Response to Submissions and Additional Information

Liverpool Hospital - Integrated Services Building
and Refurbishment Works Corner Elizabeth Street
and Goulburn Street, Liverpool

09 September 2020 | 218264

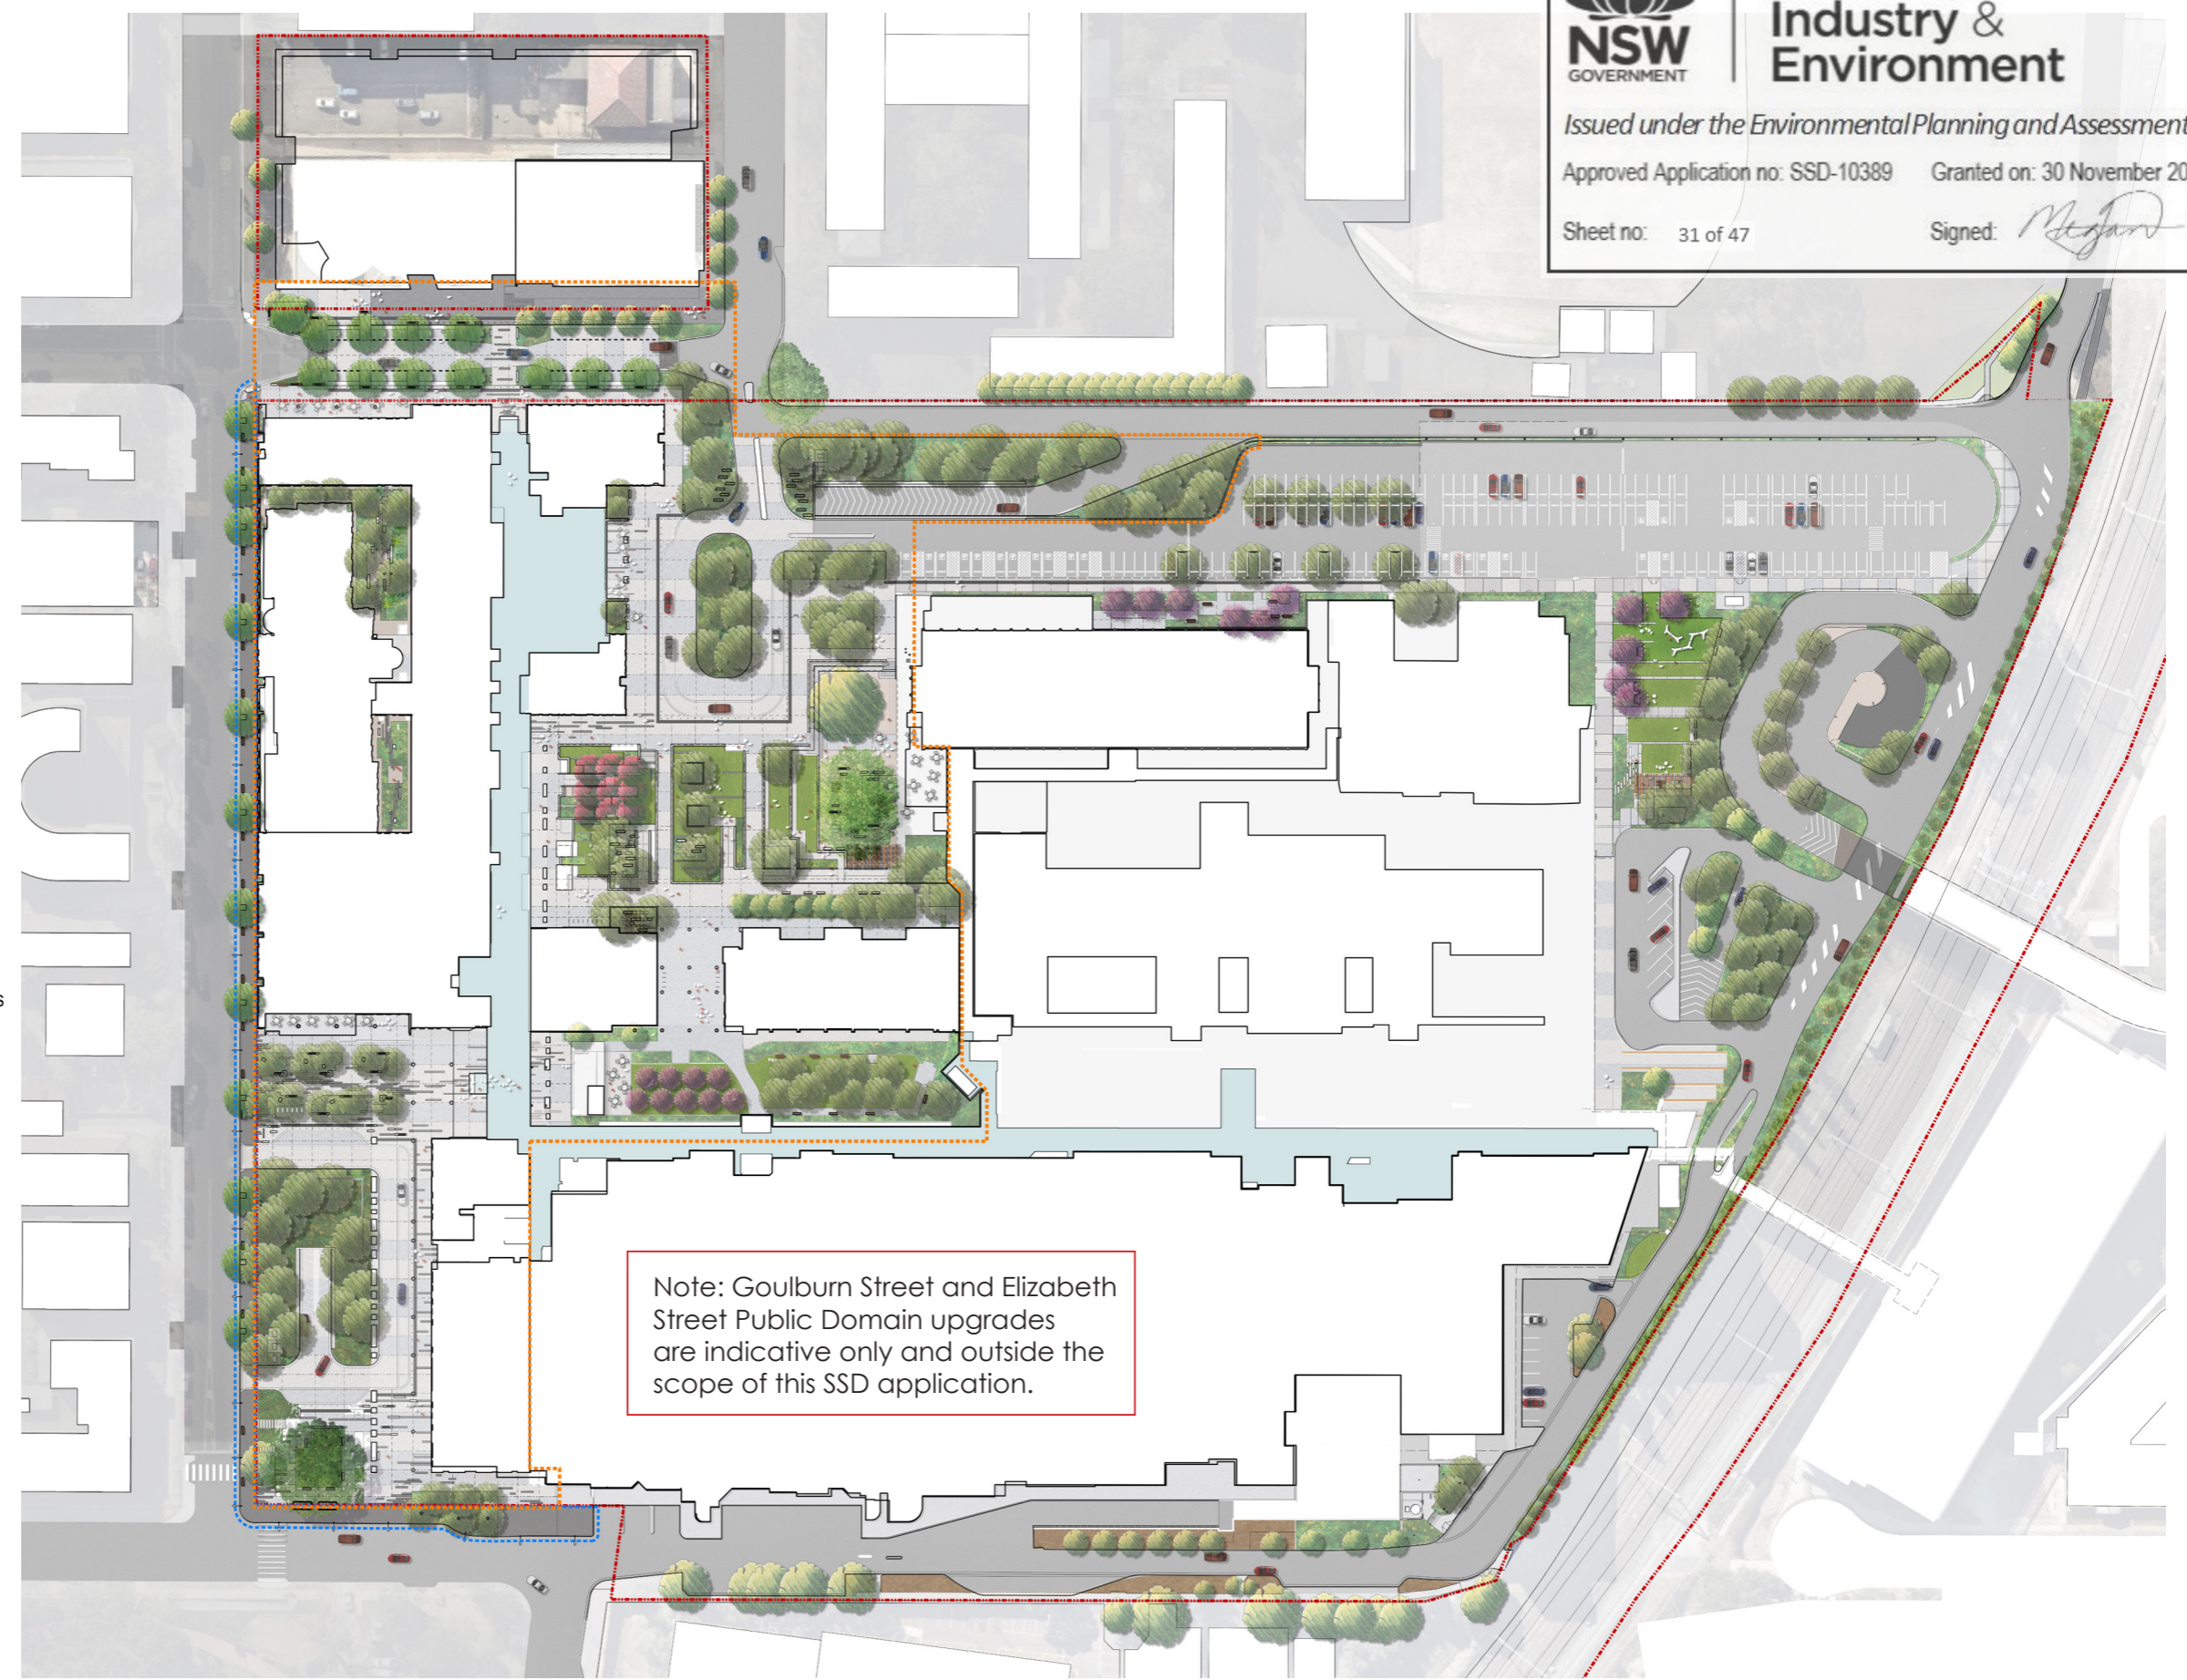
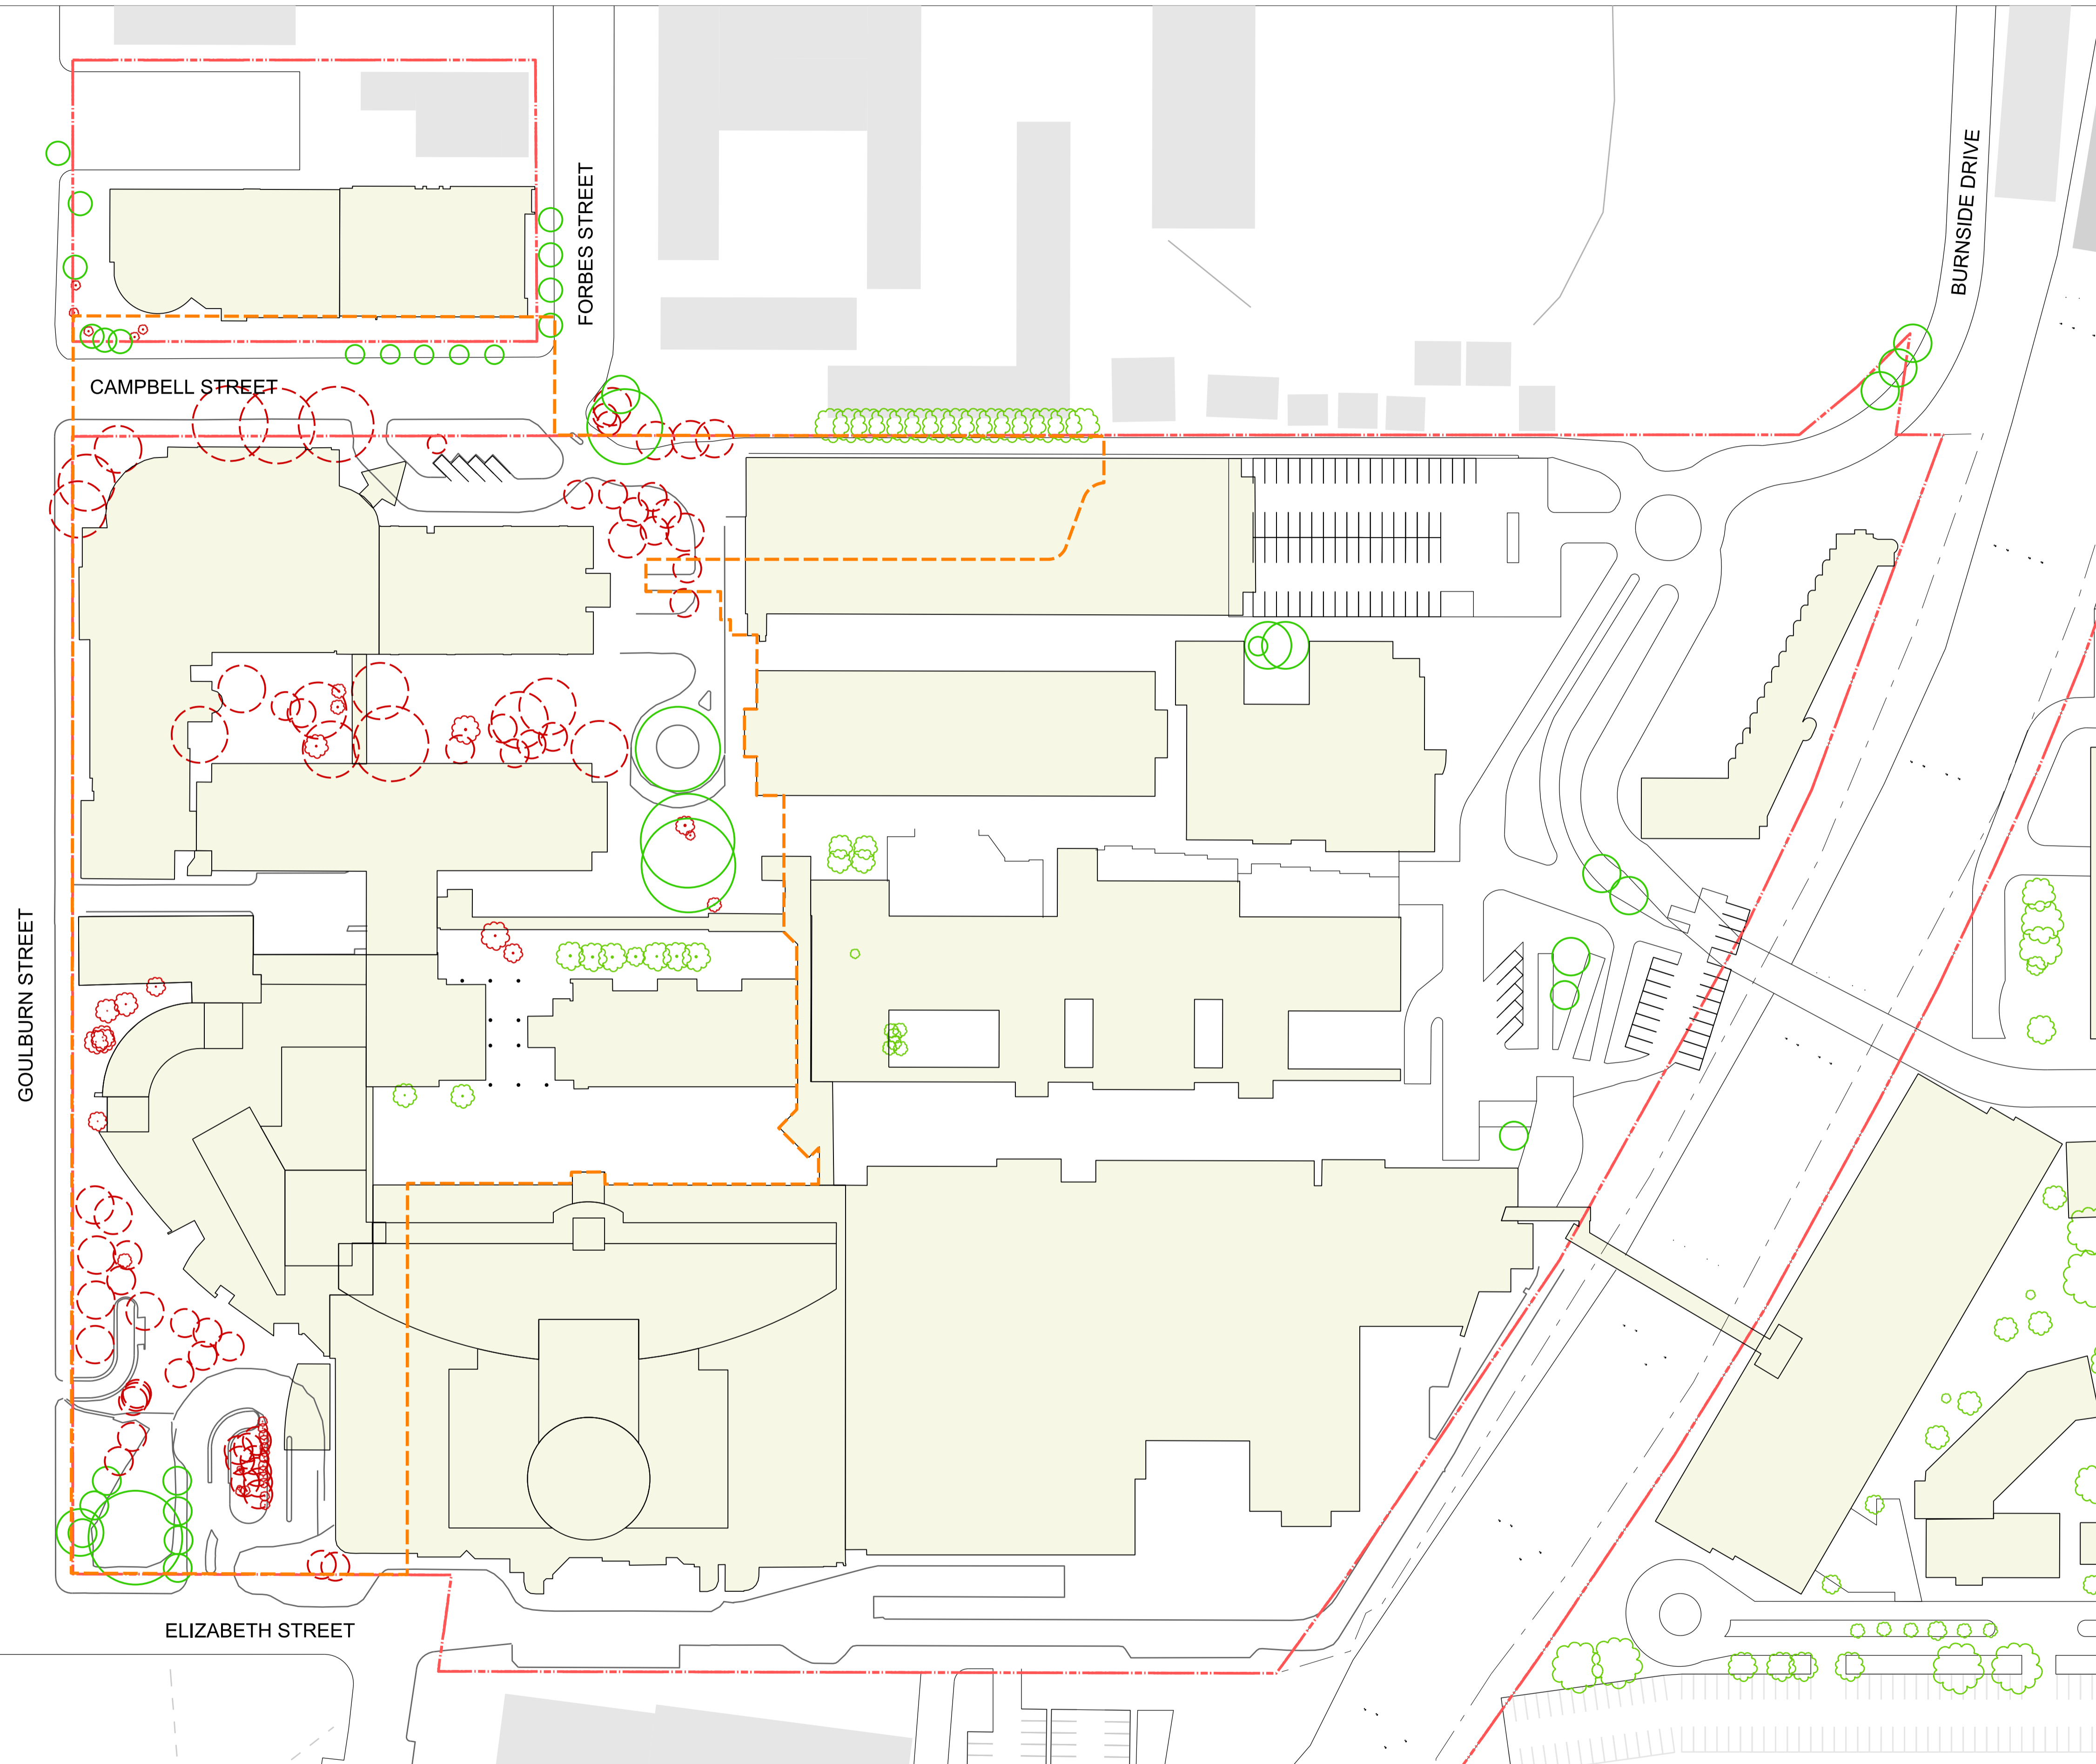
The amended Landscape Plans prepared by Clouston included at **Appendix D**, illustrate an improved design transition from the Goulburn Street footpath (granite) to the forecourt paving (concrete with granite band) as well as additional granite banding at the boundary. The site's Goulburn Street frontage will also provide additional seating at the forecourt near the corner of Elizabeth Street. This is shown at **Figure 1** and **Figure 2** below.
